27 April 2018

SSD 8574 Waitara Public School Redevelopment Application - objection

Option 1

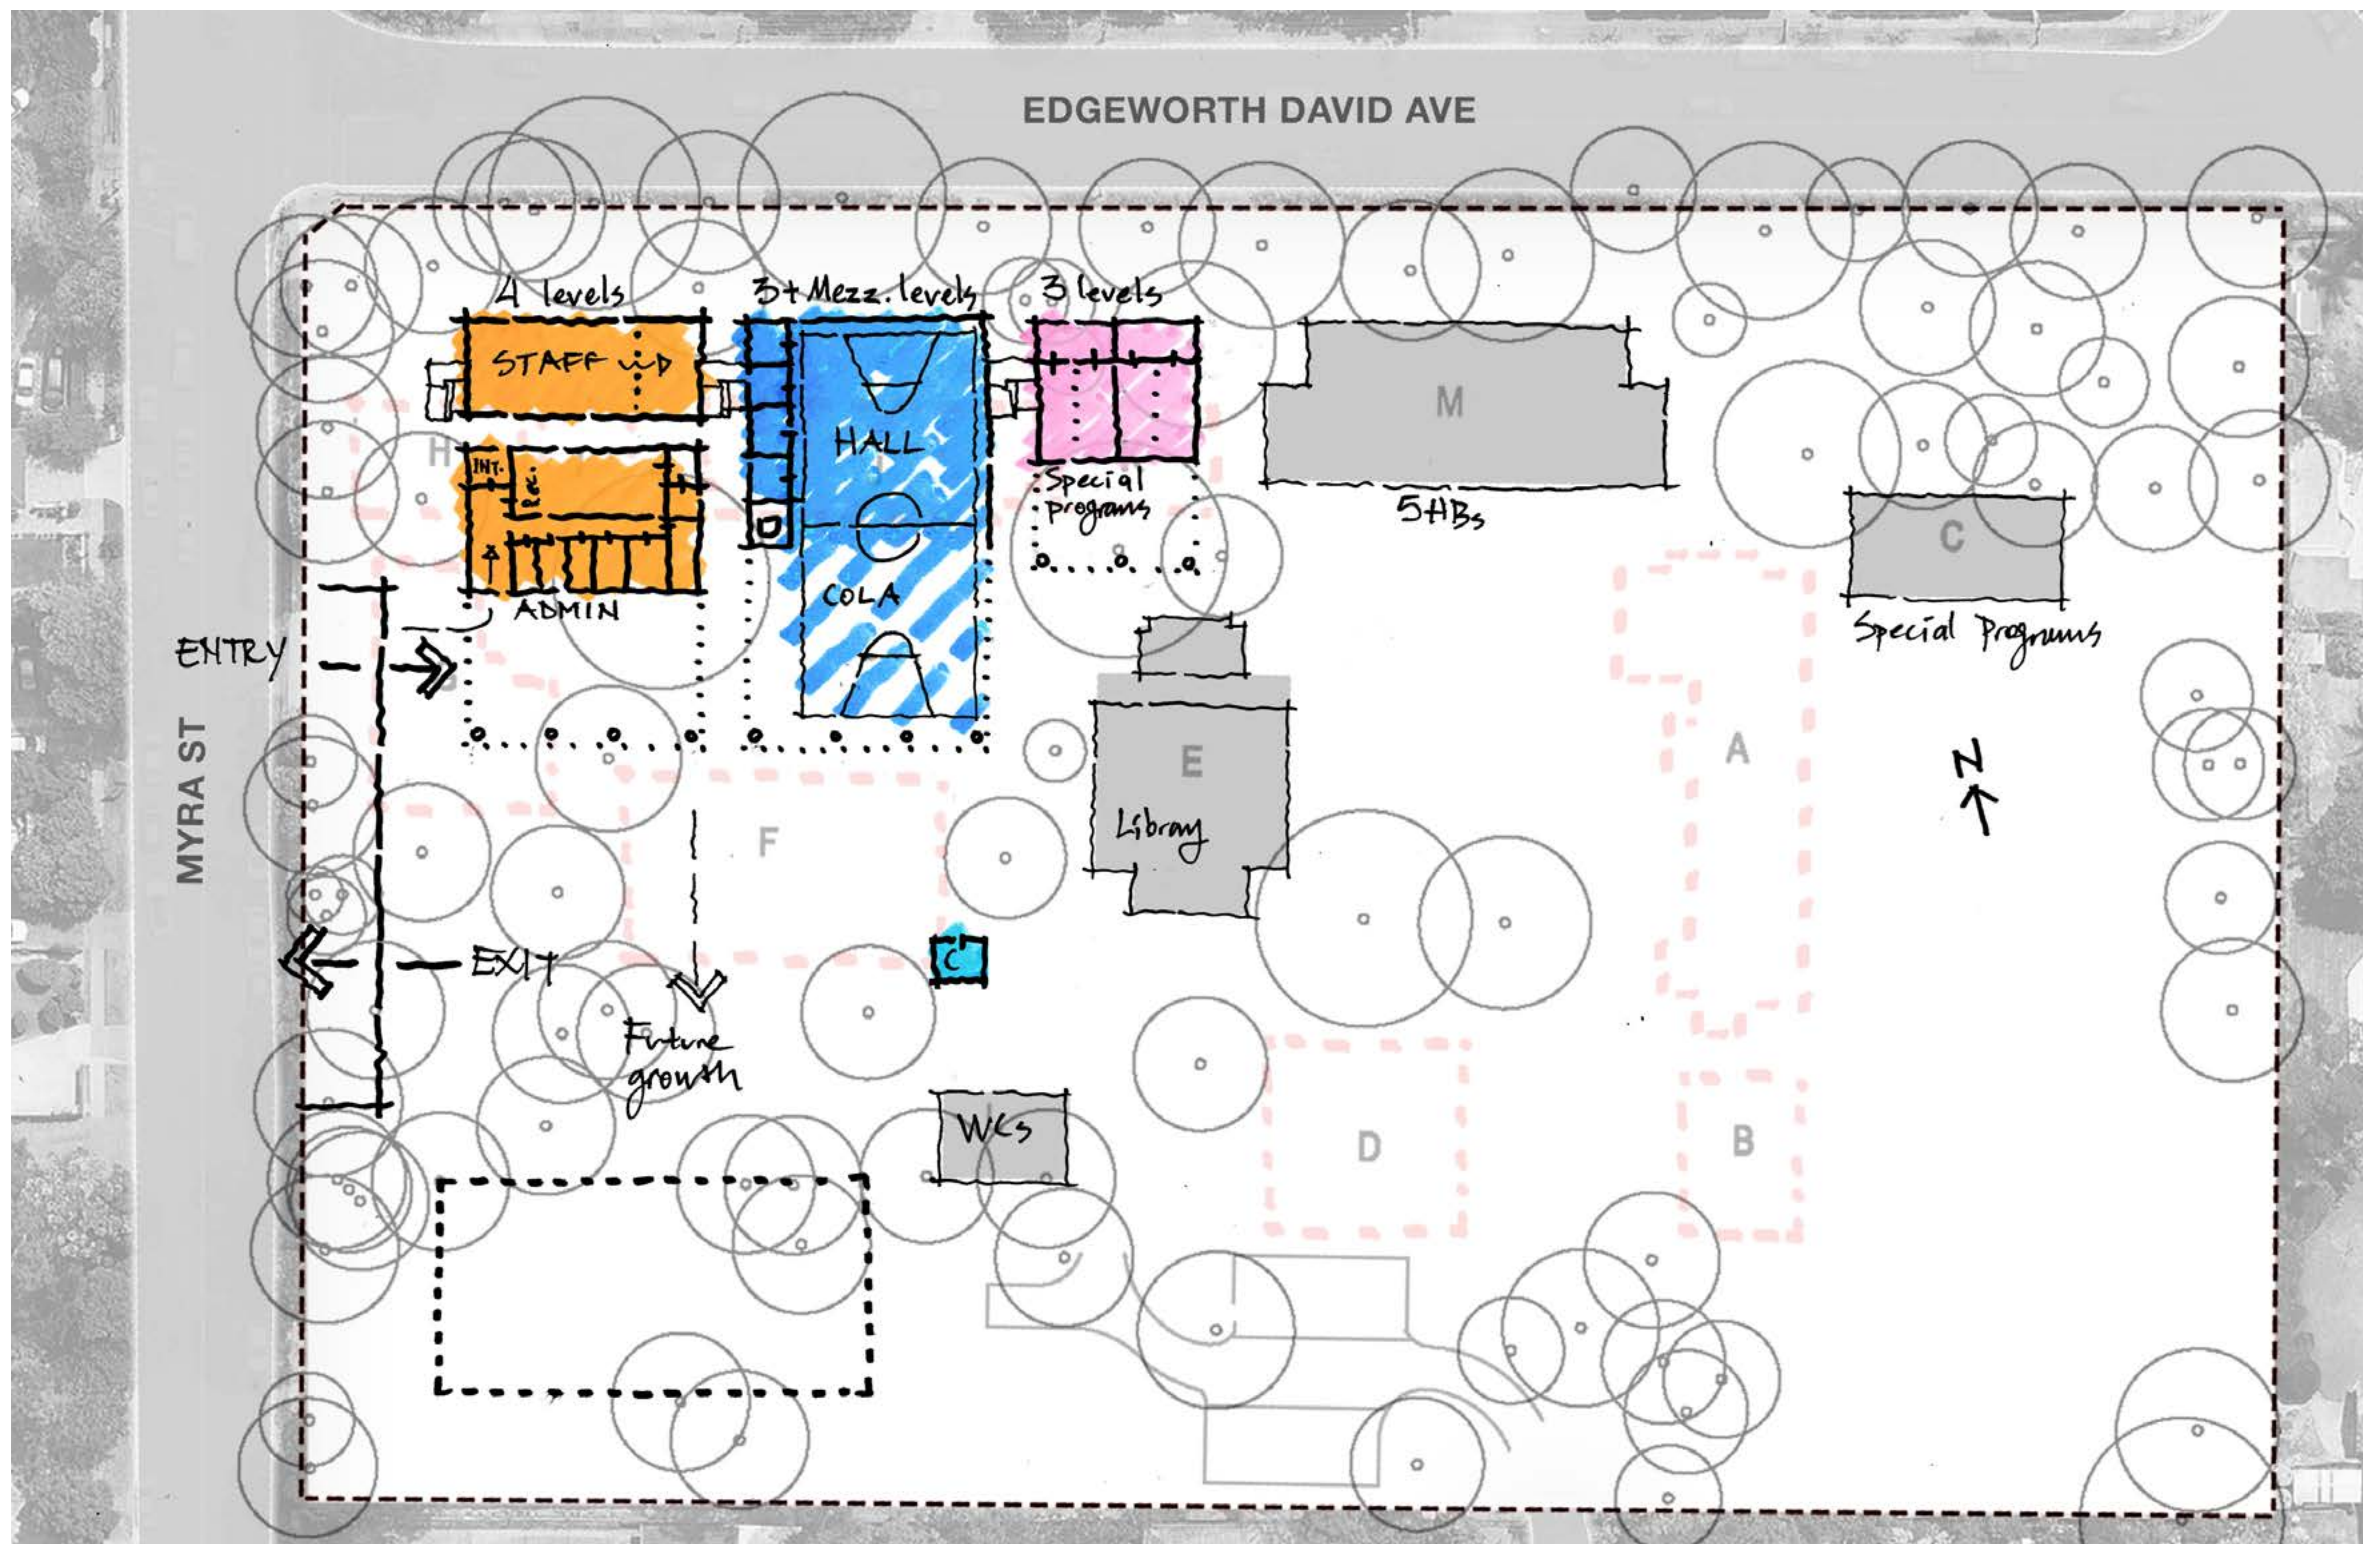
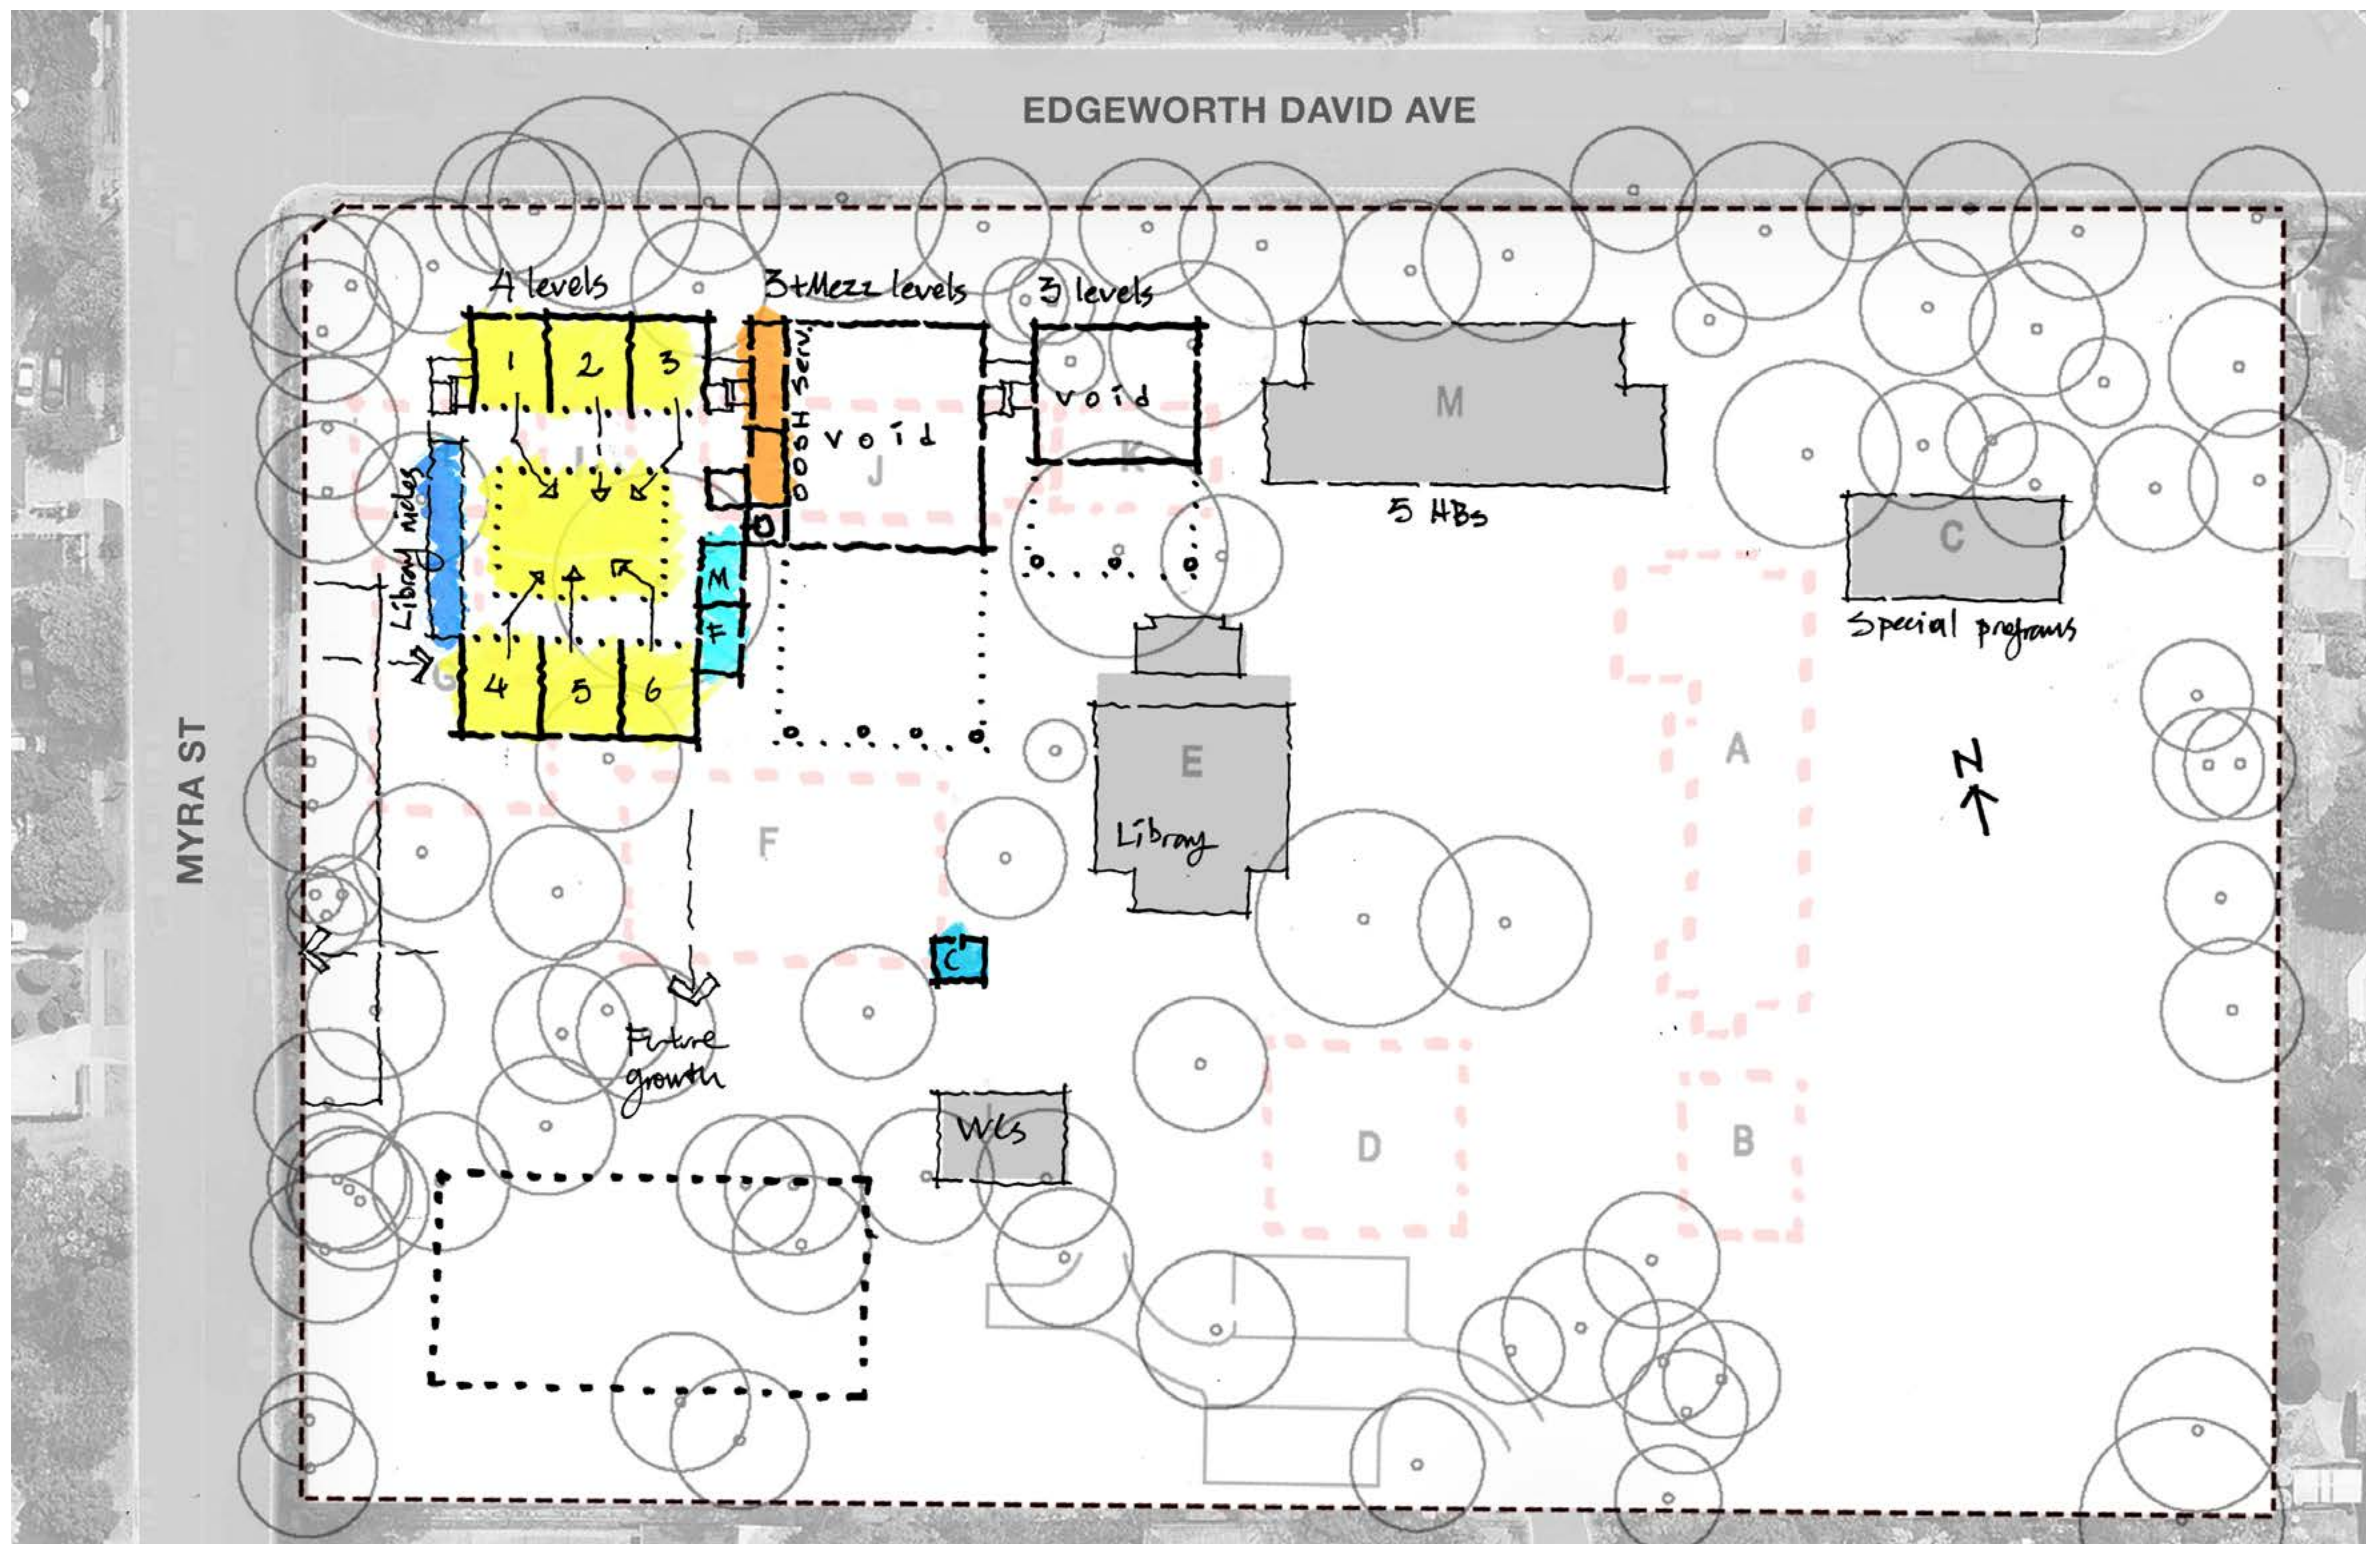
In this regard, the preliminary plans prepared by GHDWoodhead (all labelled Option 1 and also exhibited on the Department's website), together with the Site Analysis drawing (01001 revision D) are disappointing. They are intellectually shallow and unimaginative. Unfortunately, the EIS is also lacking in this regard and merely goes through the standard motions of superficially justifying the proposed building height variation. All these mentioned DA submission components fail to examine how the proposed height impact and related suburban character effect could be reduced, i.e., improved upon.
